File no: SSD 9809; MC-19-00001.

21 November 2019

**Re: SSD9809 - Richmond Road, Marsden Park – Marsden Park Public School**

## ATTACHMENT A

Title
TEMPORARY SCHOOL PLAN
SHEET 1 OF 2

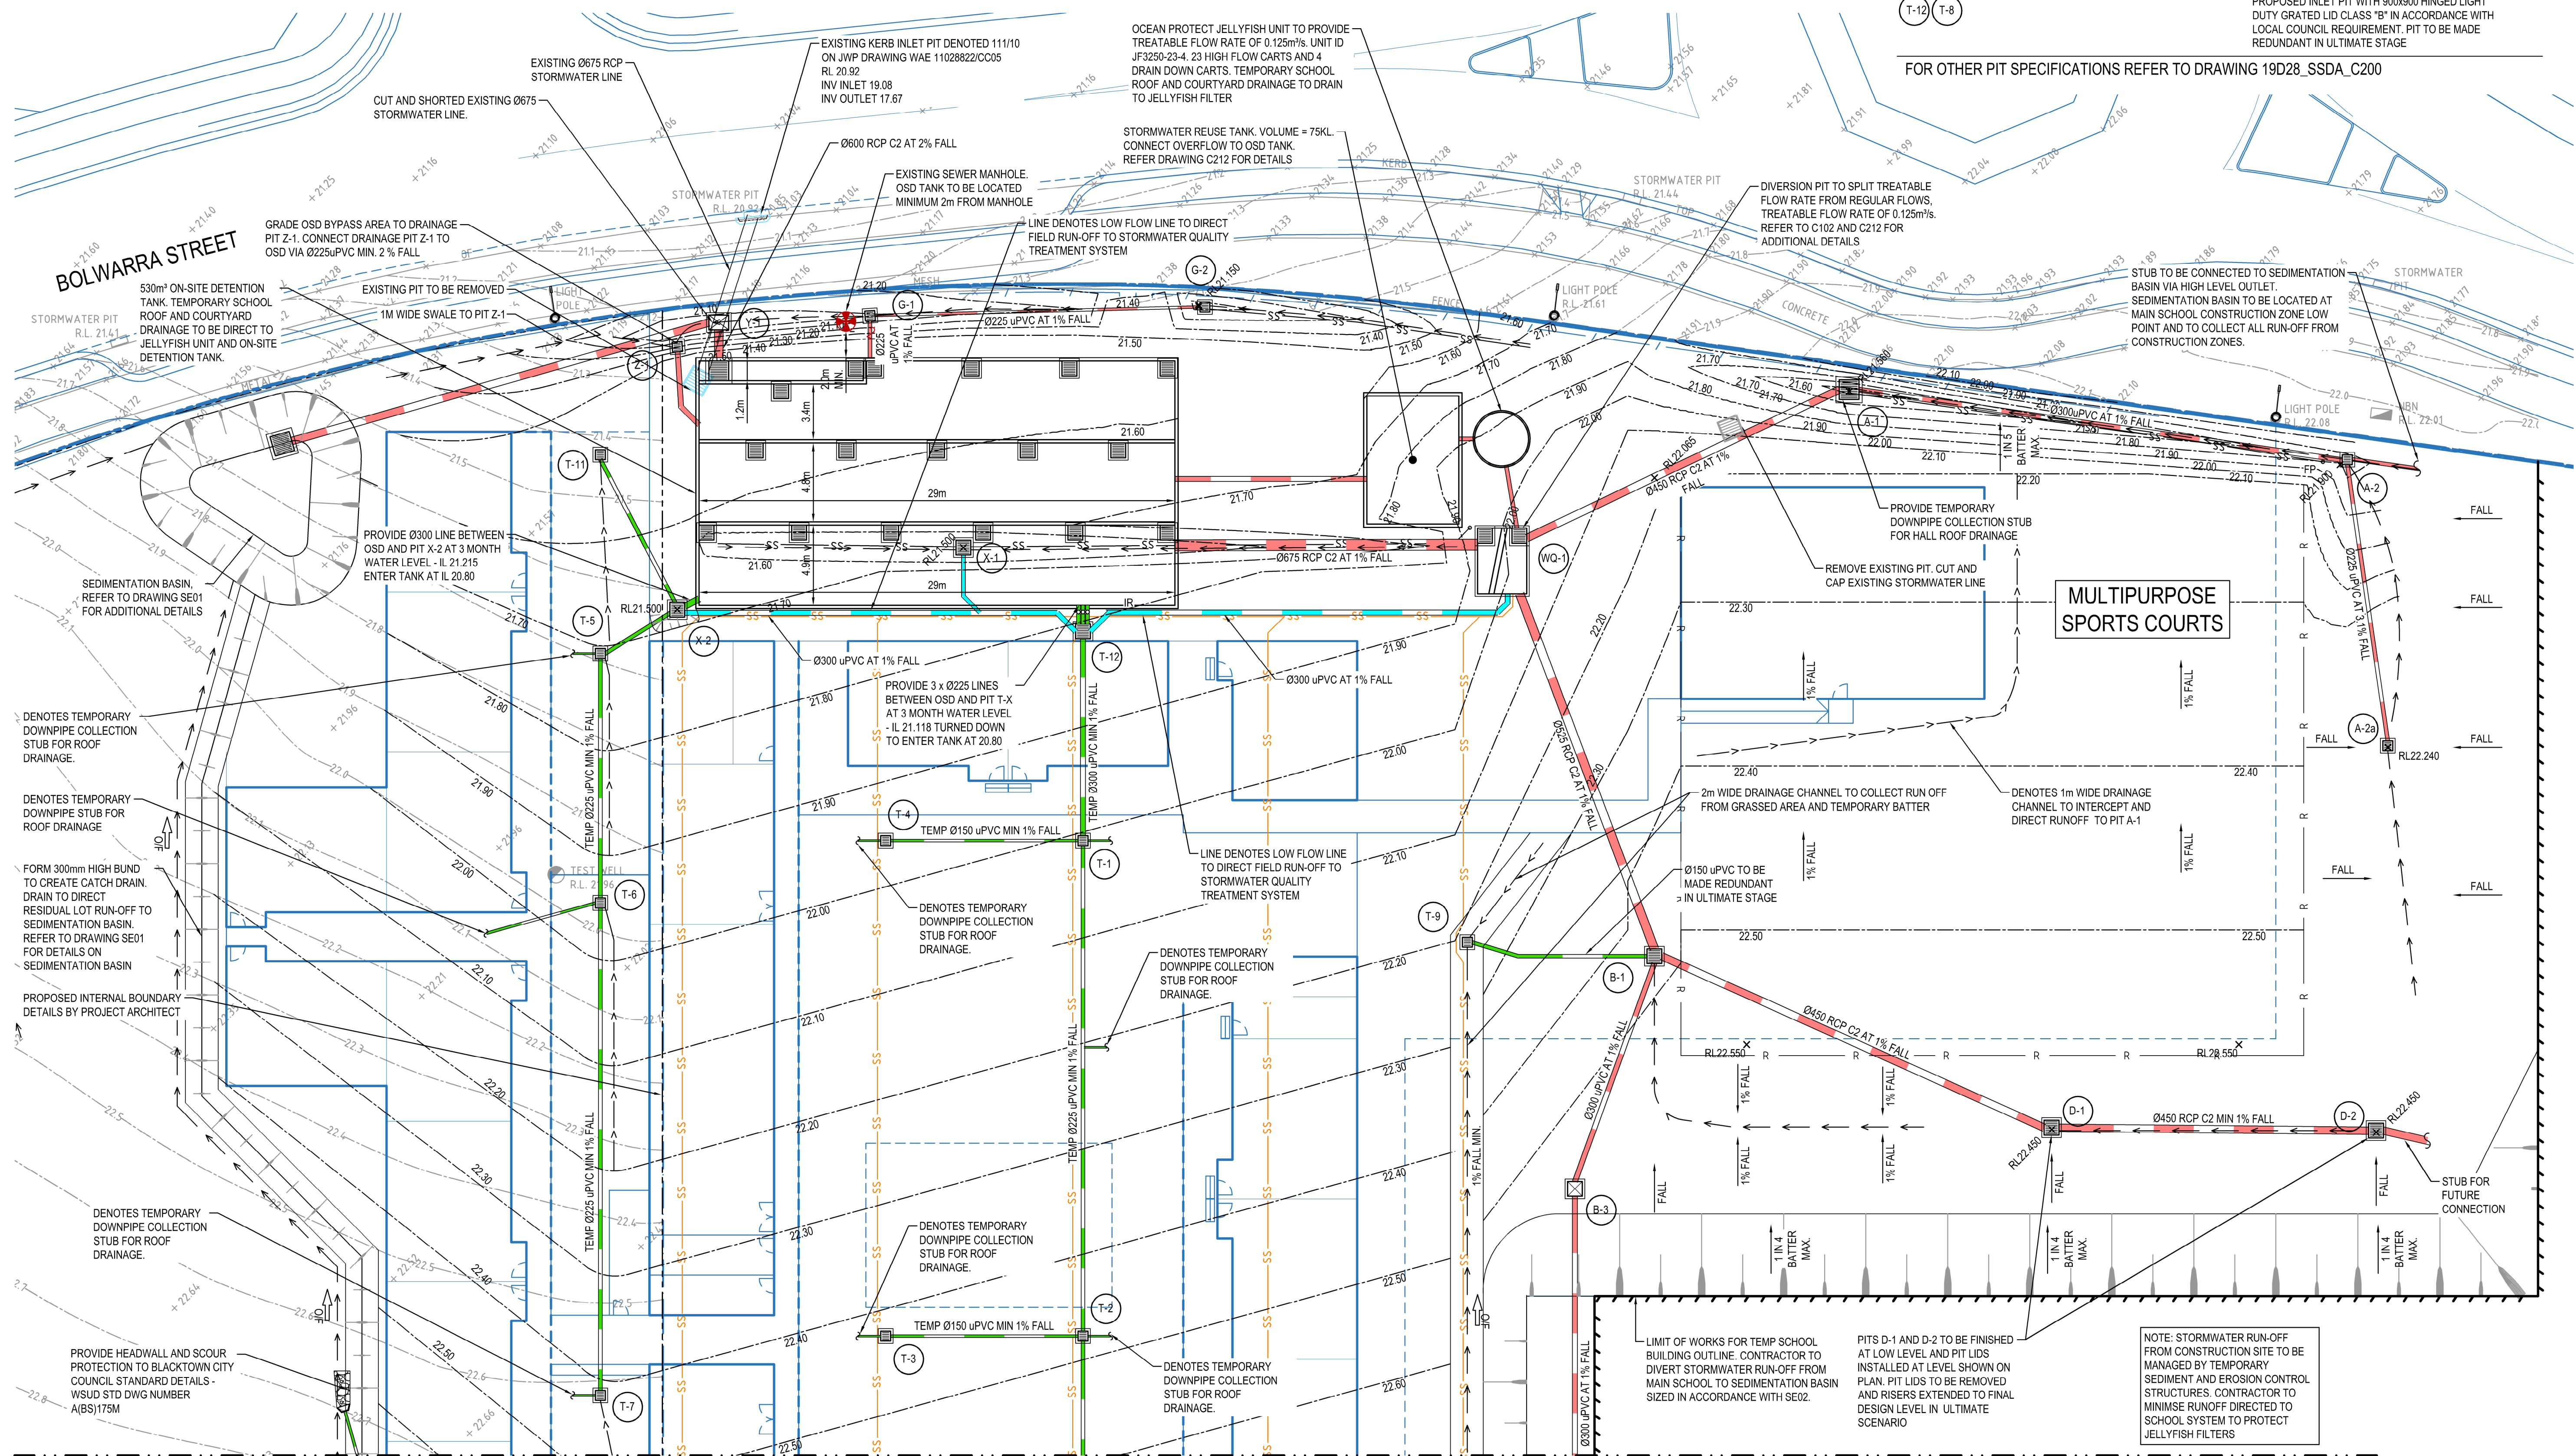
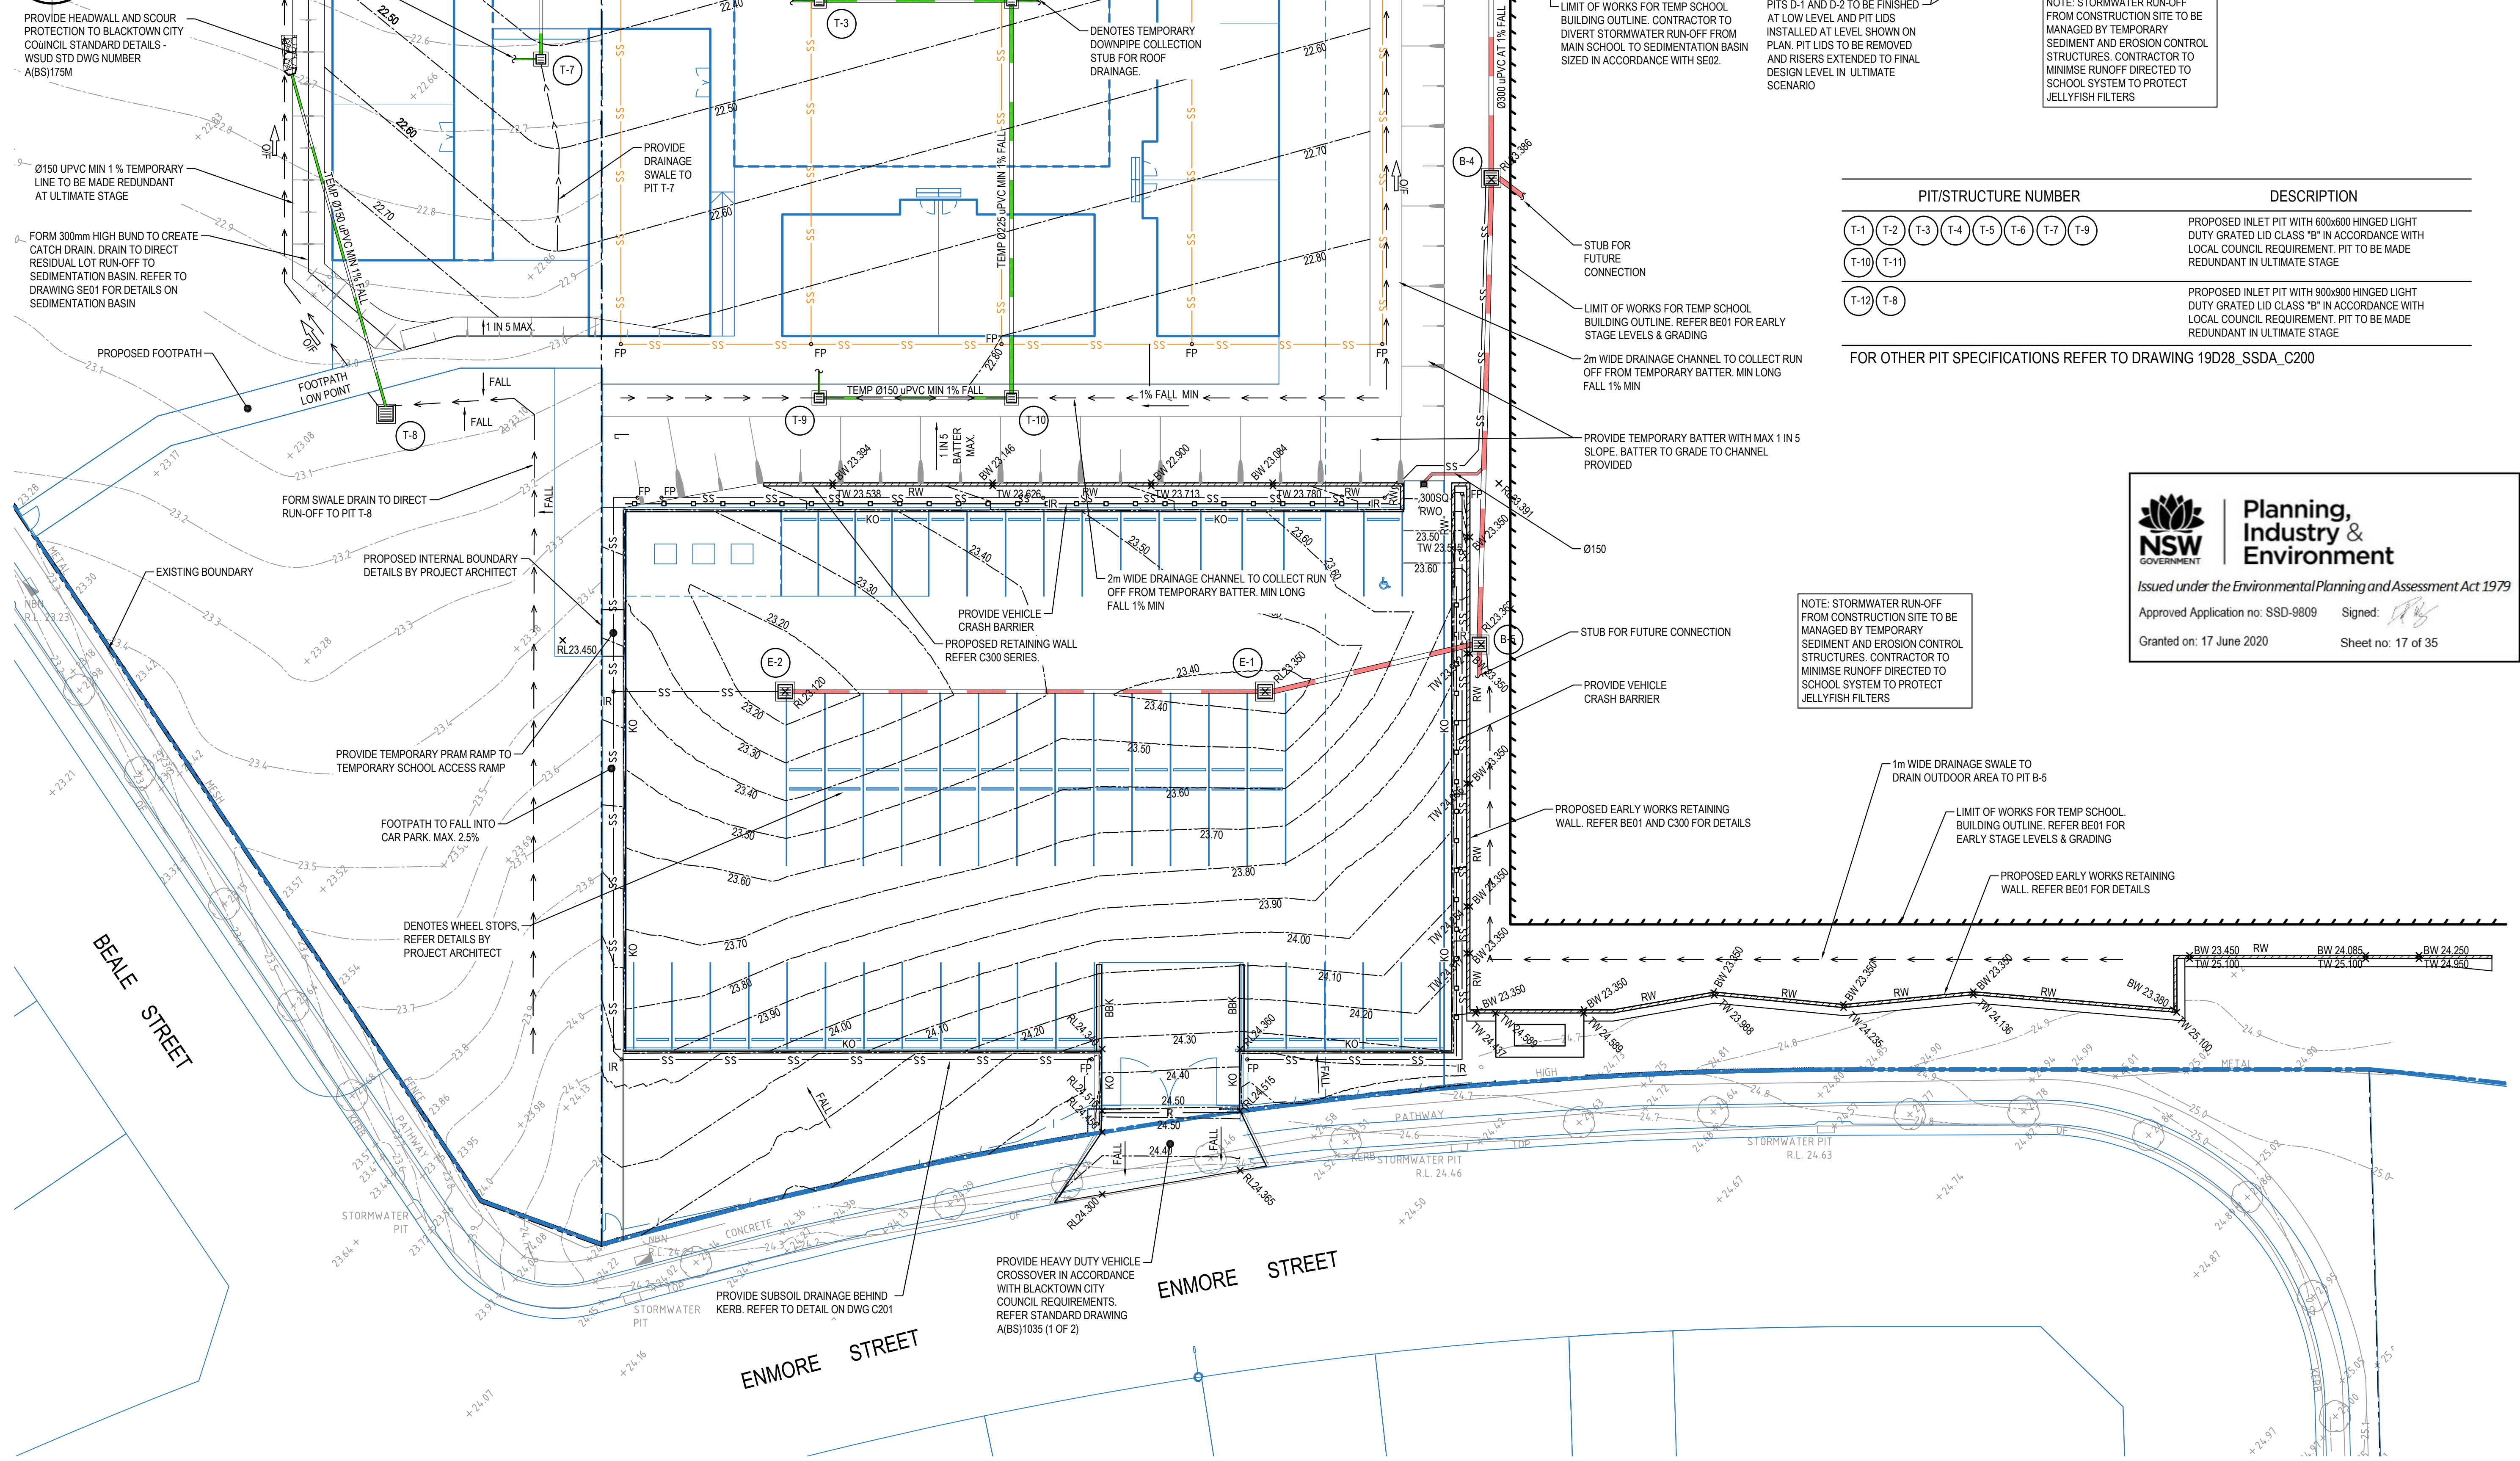
1. A stormwater design plan shall be prepared for the 'temporary school' scenario.
2. We cannot support the proposed on-site detention (OSD) storage volume of 130m<sup>3</sup>. Storage volumes shall be provided in the order of:

ORIFICE CALCULATIONS

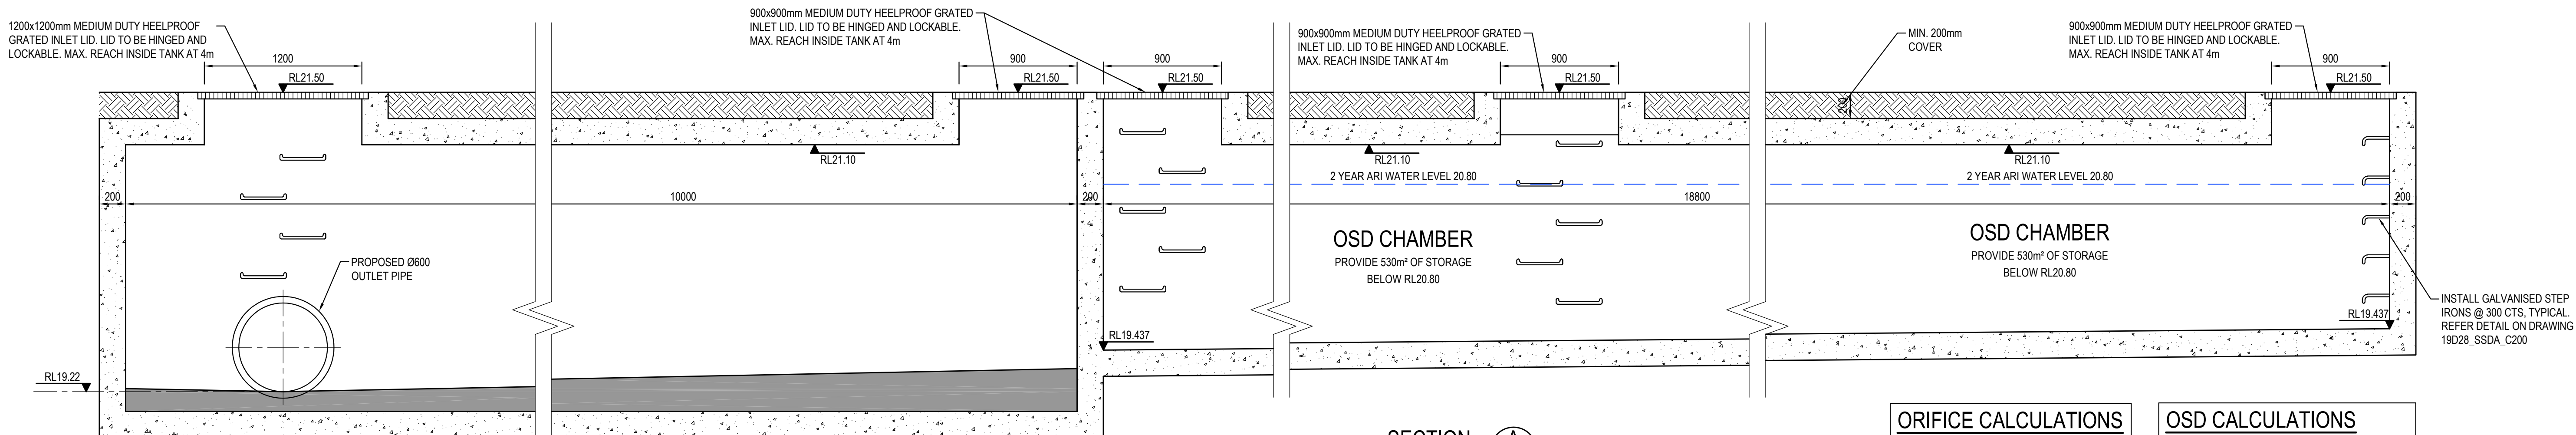
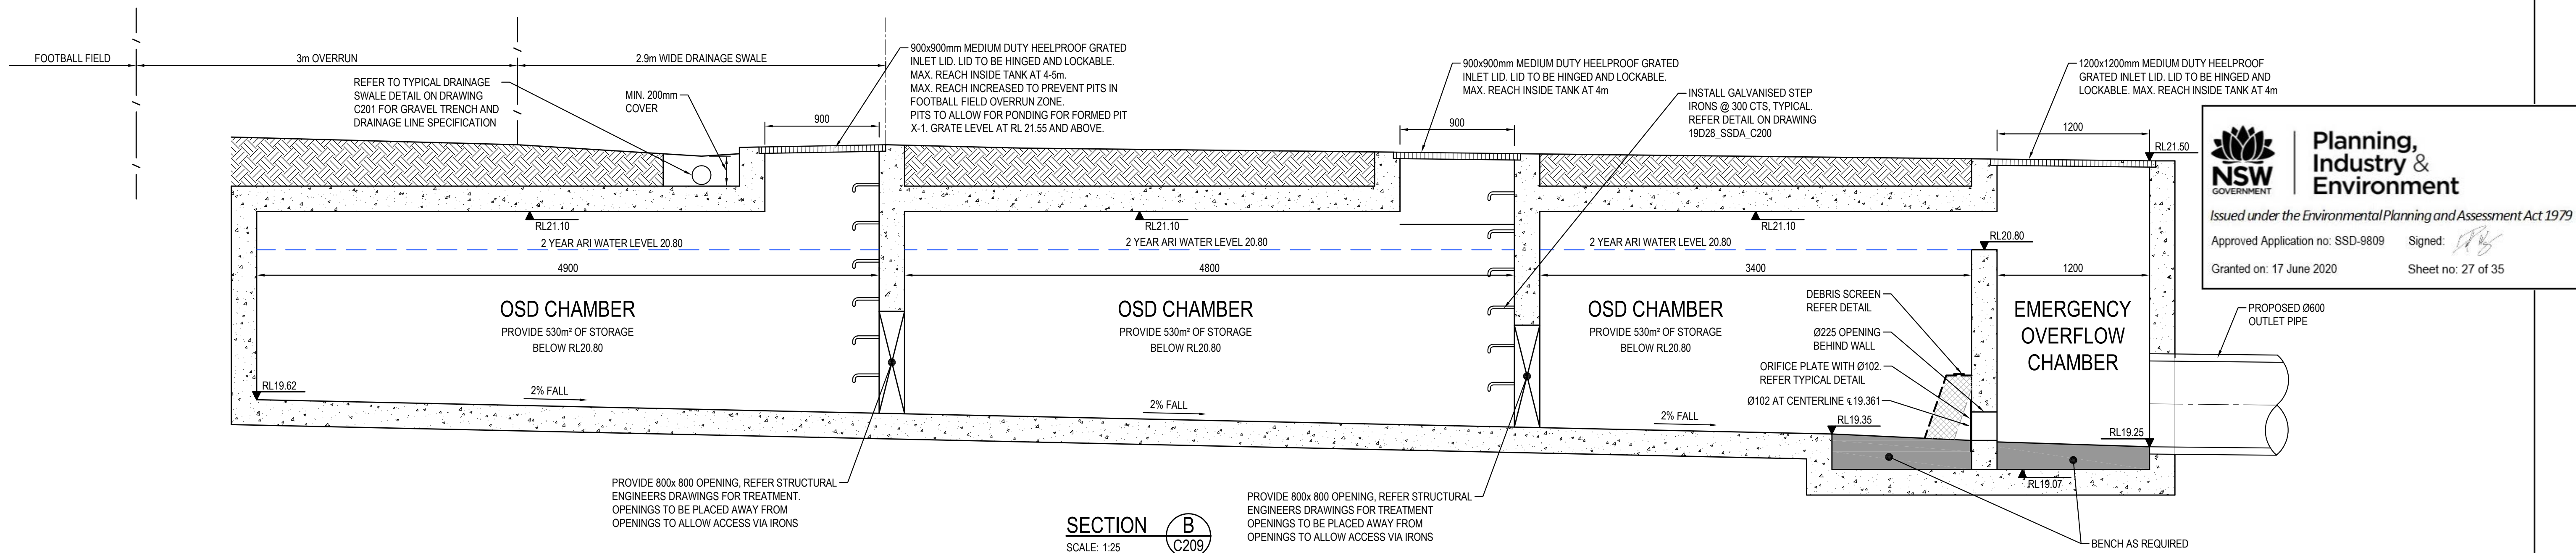
- a) 300m<sup>3</sup>/Ha up to the 1.5 year ARI top water level; and
  - b) 455m<sup>3</sup>/Ha up to the 100 year ARI top water level;as per Council's Water Sensitive Urban Design Standard Drawings, Drawing No. A(BS)175M, Page 20.

3. OSD details including cross sections shall be provided in the stormwater plan set. The OSD shall be designed in accordance with Council's Water Sensitive Urban Design Standard Drawings, Drawing No. A(BS)175M, Page 22/23.
